Response to Submissions Report - August 2015

**Kembla Grange Resource Recovery Facility
Building Material Storage and
Resource Recovery Facility Exceeding 30,000 Tonnes per Annum and
Redesign and Expansion of Approved Facility**

**Lot 10 DP 878167
50 Wyllie Road, Kembla Grange
Application No. SSD-5300**

Prepared for Bicorp Pty Ltd

Figure 15 – Predicted – Cumulative PM₁₀ 24-hour Average Concentration (with mitigation) µg/m³

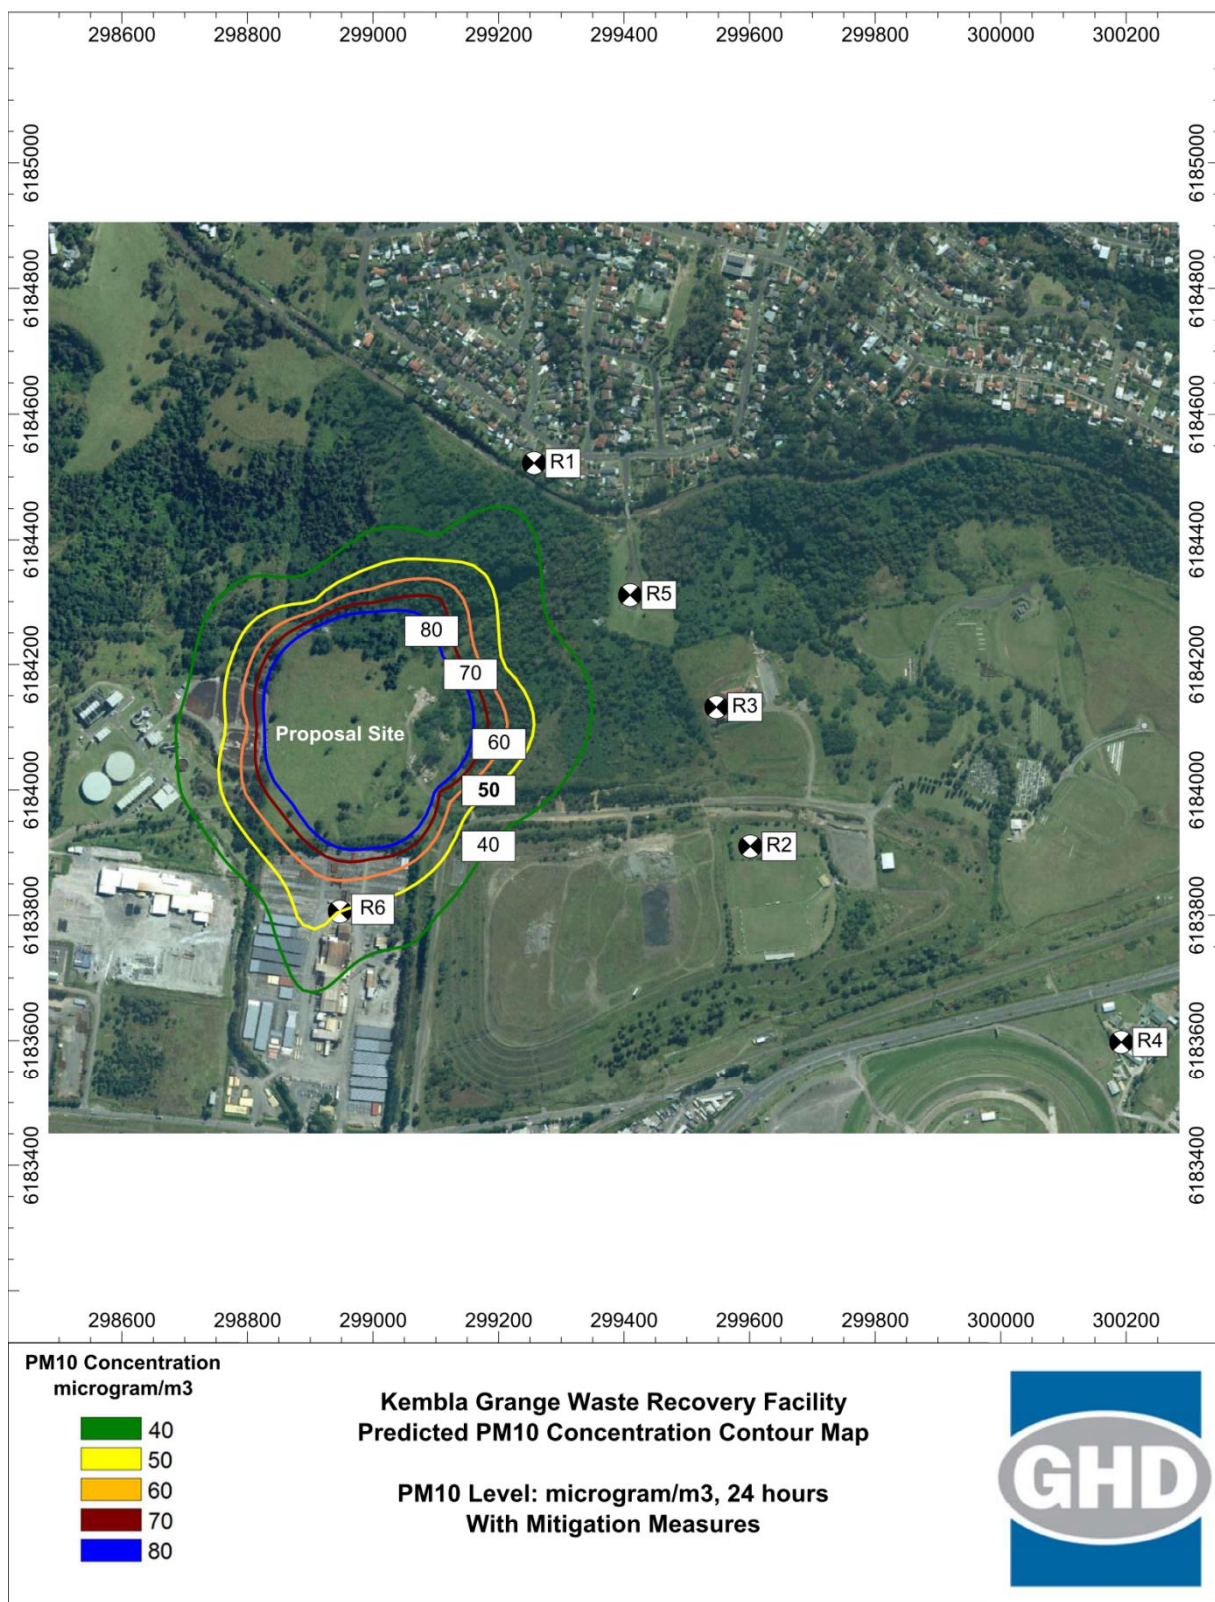
"... GHD have predicted the dust deposition rates based on a sensitive receiver at our property boundary whilst modelling the sensitive receivers for the other impacts based on a location at the northern edge of the site's building named 'R6'.

At this location the proposed development is forecast to create a cumulative PM10 impact of 49.3µg/m³ against an impact criteria of 50µg/m³. The forecast is within 1.4% of the criteria limit.

The borderline PM10 result is confirmed by Figure 15 of the GHD assessment "Predicted Cumulative PM10 24-hour Average Concentration (with mitigation) µg/m³" (included below). The location of the sensitive receiver "R6" appears to be located on the PM10 cumulative impact contour level 50µg/m³. This contour level defines the area of impact within which the PM10 impact criteria would be exceeded. Had the sensitive receiver R6 been located 10 metres further west or north, Figure 15 shows it is highly likely the criteria would be exceeded. GHD modelled a location on our northern boundary when predicting dust deposition impacts. Had GHD used the same "conservative" assumption for predicting PM10 impacts, it would have exceeded the criteria. We do not have confidence that the Air Quality Assessment's results are valid when the conclusions of the assessment appear to be highly sensitive to variations in the location and sensitive receiver.

costs". Consequently, Patrick submit that it would be more appropriate for sensitive receiver R6 to be placed on the northern boundary.

- The **receptor location R6** has been moved to the northern boundary of the Patrick site for both the odour and dust assessments. The location has been chosen to take into account maximum dust and odour impacts from the proposal. This can be seen on all figures in the air quality assessment.

Figure 17 – Predicted –Annual dust deposition (with mitigation) $\text{g/m}^2/\text{month}$

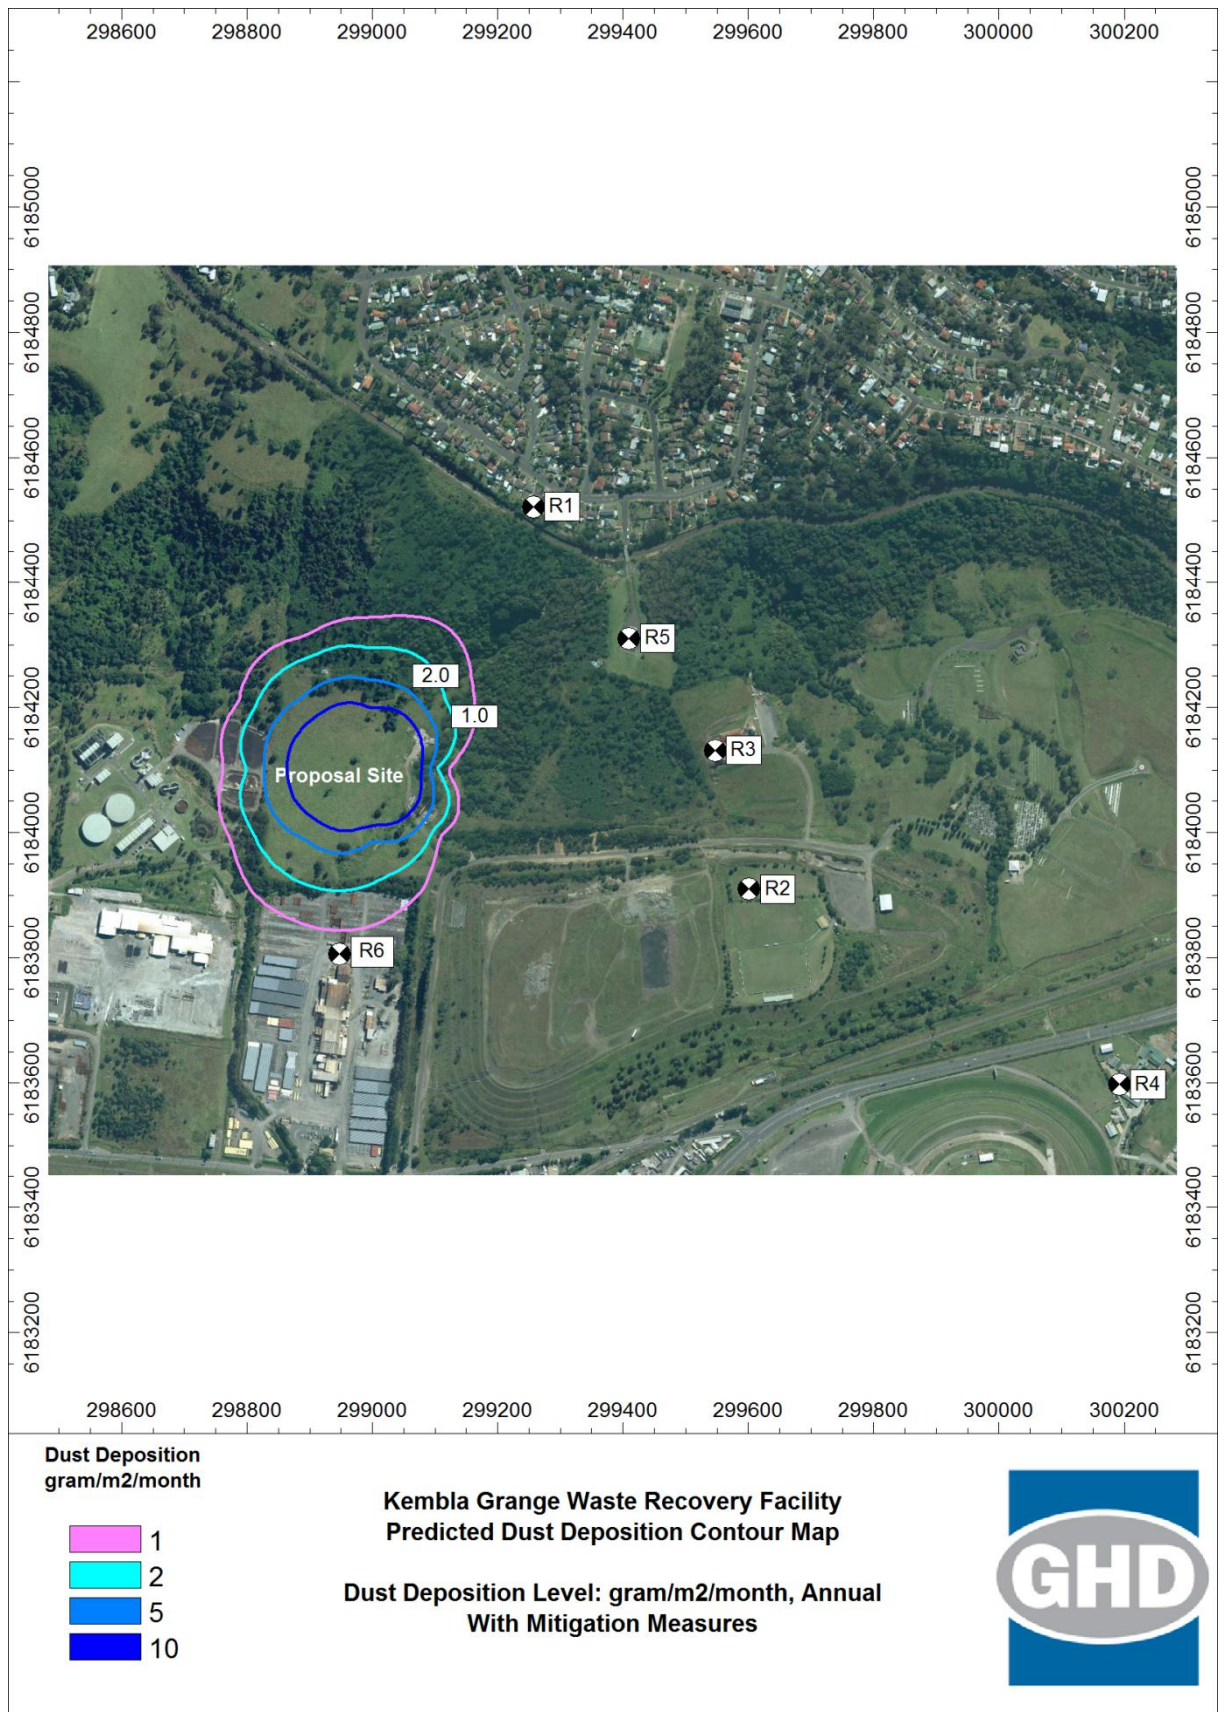
However Figure 17 of the GHD assessment "Predicted Annual dust deposition (with mitigation) g/m²/month" (included below) shows the location of the PAC Sensitive Receiver "R67" on the northern property boundary is not shown. To provide clarity the location of both receivers should be shown on Figure 17.
